Application No: WA/50/20/RES
Site Address: Former Lanes End House West Walberton Lane Walberton BN18 0QS
Description of works: Approval of reserved matters following outline consent WA/26/18/OUT for appearance, landscaping, layout & scale for the demolition of 1 No. dwelling & the erection of 6 No. dwellings (resubmission following WA/7/19/RES).

Thank you for your internet representation made on 29th October 2020 which has been recorded as an objection with the comments as follows:

PLOT 6
FLOOR PLANS AND
ELEVATIONS

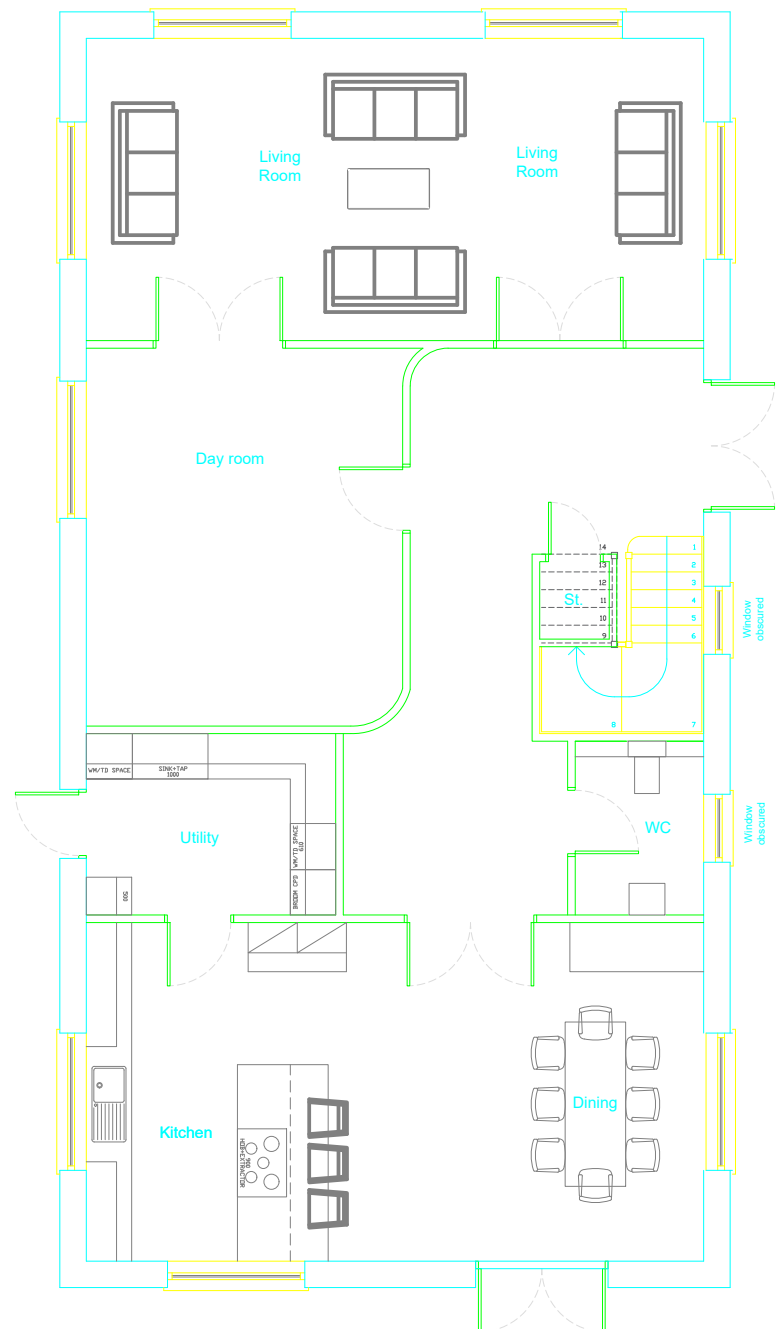
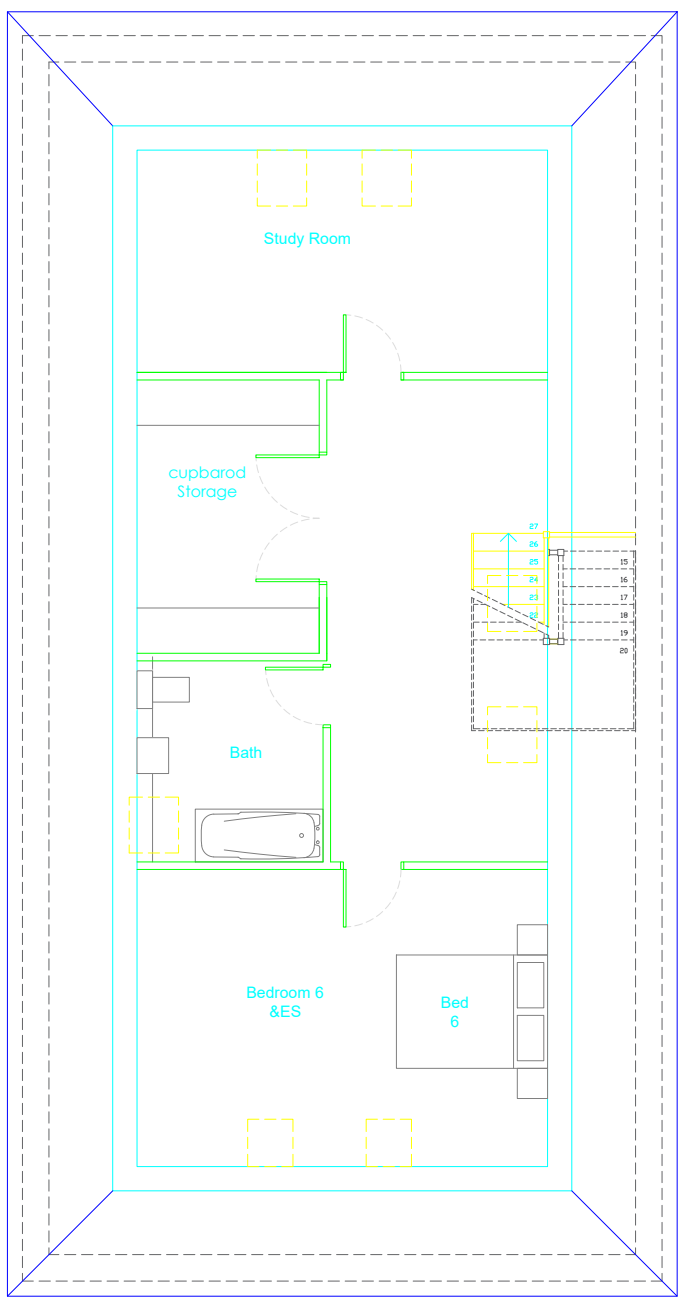
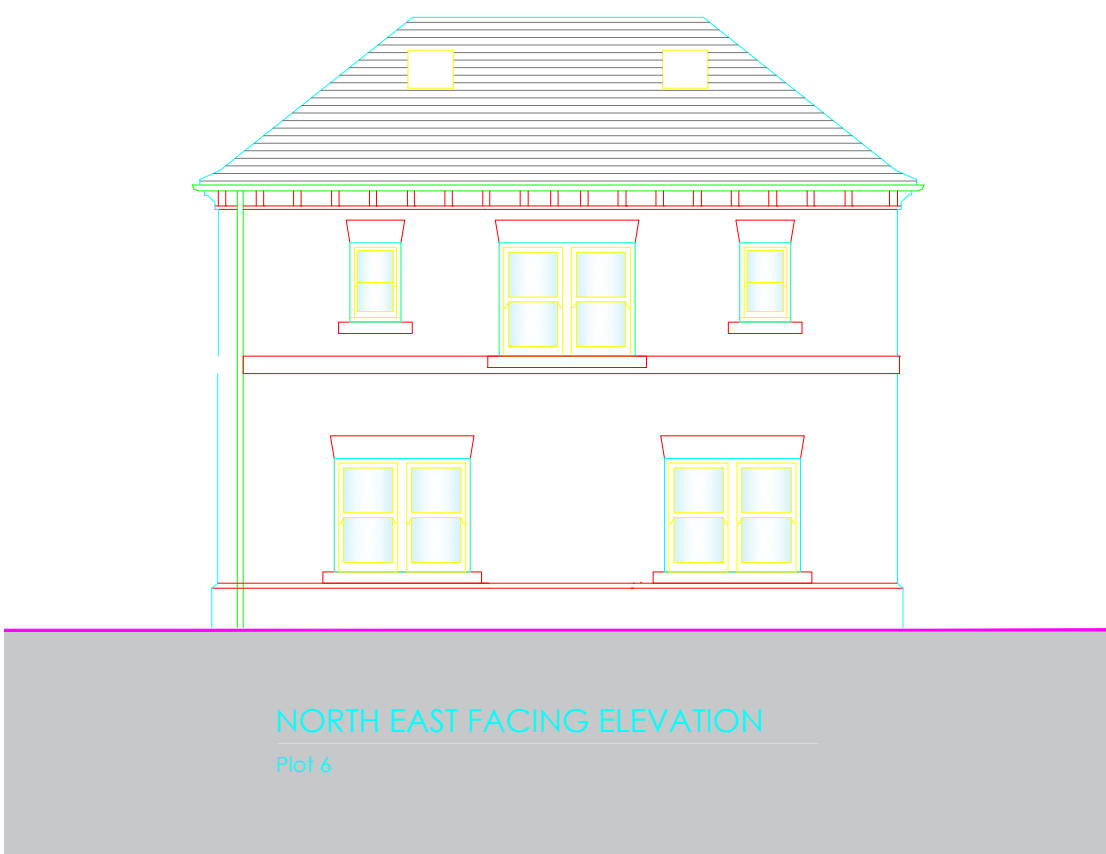
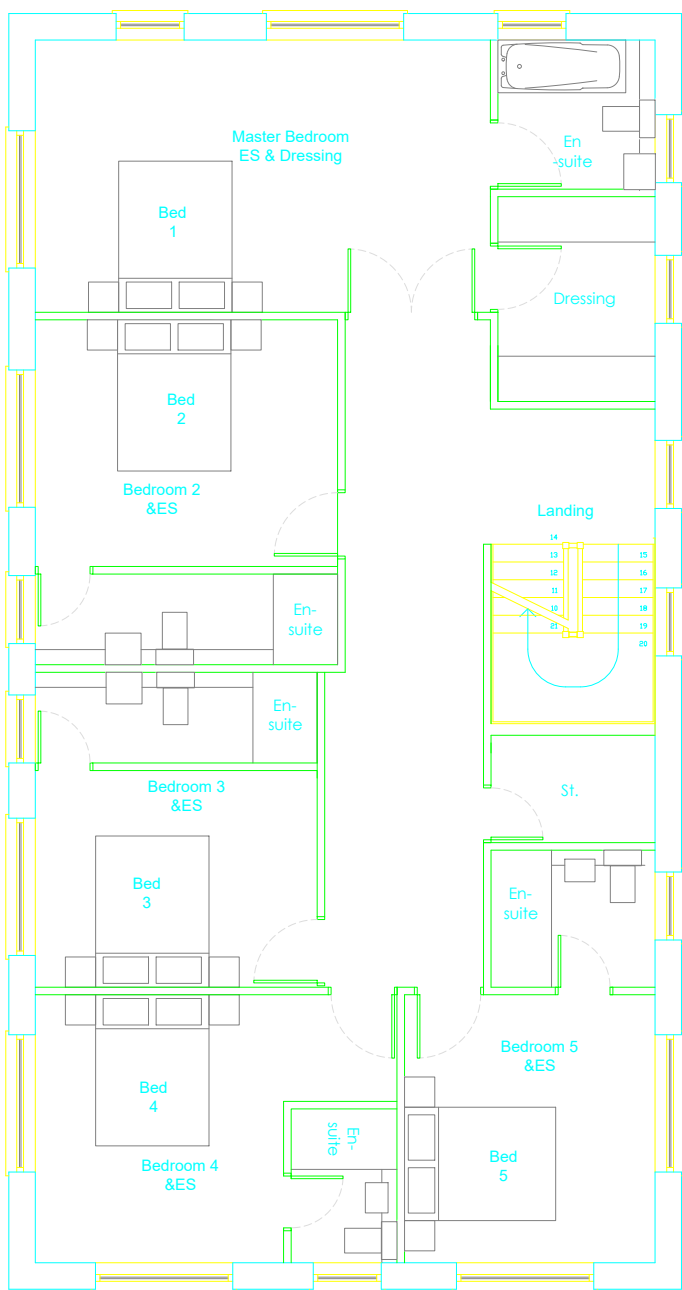
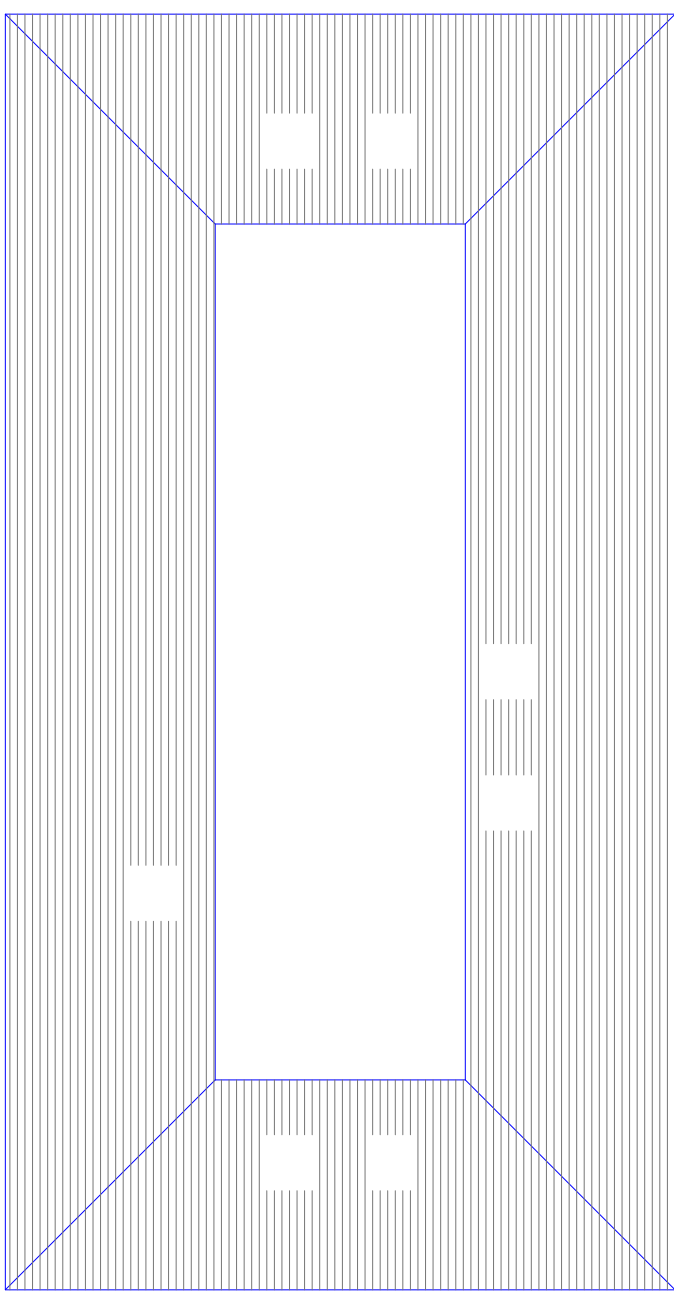
The plot 6 house is shown as a 3 storey 6 double bedroom layout with a different appearance to the others on the estate.
